From: Jessica Rousseau (LFR) <Jessica.Rousseau@lincolnshire.gov.uk>
Sent: 30 October 2025 13:34
To: Niland, Mark
Cc: _planningadvice
Subject: South Holland DC Planning - Consultation request

Application Ref: H05-0439-25
Address: Land West of Branches Lane
Proposal: Use of site to construct new primary substation

PROPOSED SITE PLAN
SCALE 1:250

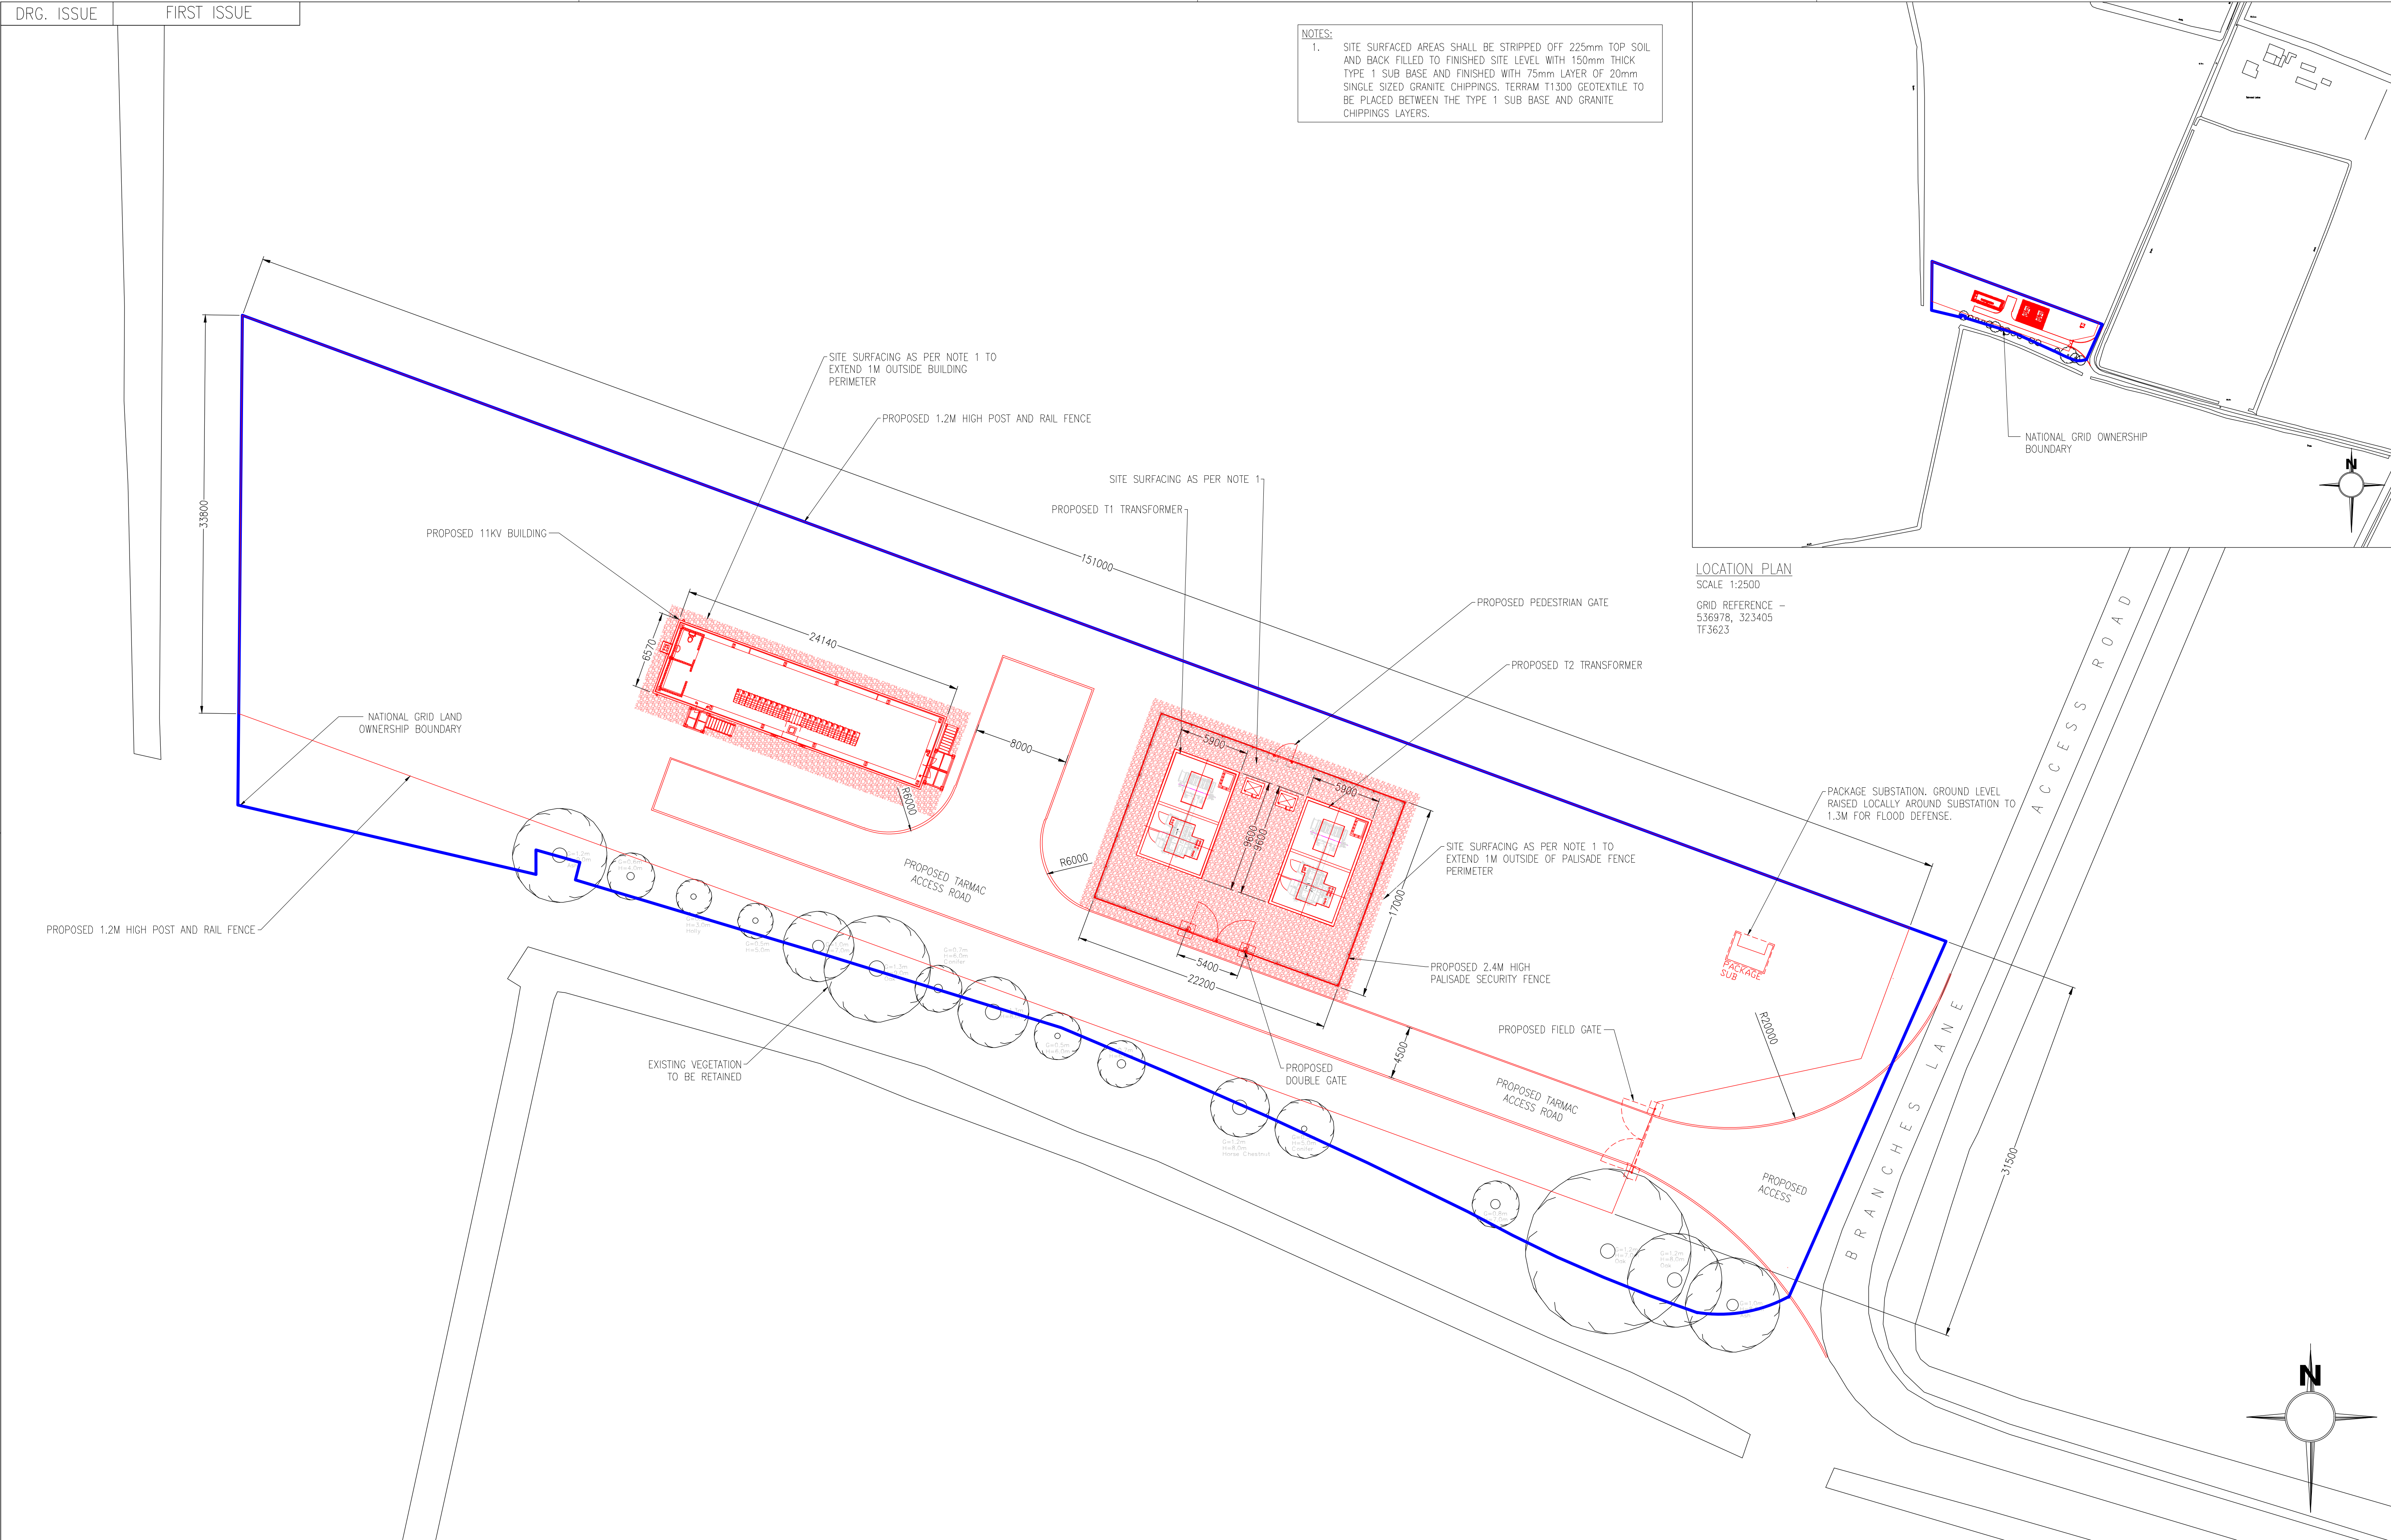
I have attached below a reference from approved document B – looking at the site plans there seems to be a building being built and therefore would not comply.

I've reviewed the compliance report. Regarding the transformers, they appear to be compliant and using the appropriate sections of the BESS guidance. However, under Building Regulations 2010 (Approved Document B - ADB), a fire hydrant should be located within 90 metres of a dwelling entrance.

While I understand there is no BESS on site—meaning a hydrant is not legally required in that section - the site does include a building. Therefore, the current setup does not comply with ADB, as there is no hydrant within the required distance of the dwelling, and therefore the reason of the initial objection.

- 16.8 A building requires additional fire hydrants if both of the following apply.
- a. It has a compartment with an area more than 280m².
 - b. It is being erected more than 100m from an existing fire hydrant.
- 16.9 If additional hydrants are required, these should be provided in accordance with the following.
- a. For buildings provided with fire mains – within 90m of dry fire main inlets.
 - b. For buildings not provided with fire mains – hydrants should be both of the following.
 - i. Within 90m of an entrance to the building.
 - ii. A maximum of 90m apart.
- 16.10 Each fire hydrant should be clearly indicated by a plate, fixed nearby in a conspicuous position, in accordance with BS 3251.
- 16.11 Guidance on aspects of provision and siting of private fire hydrants is given in BS 9990.
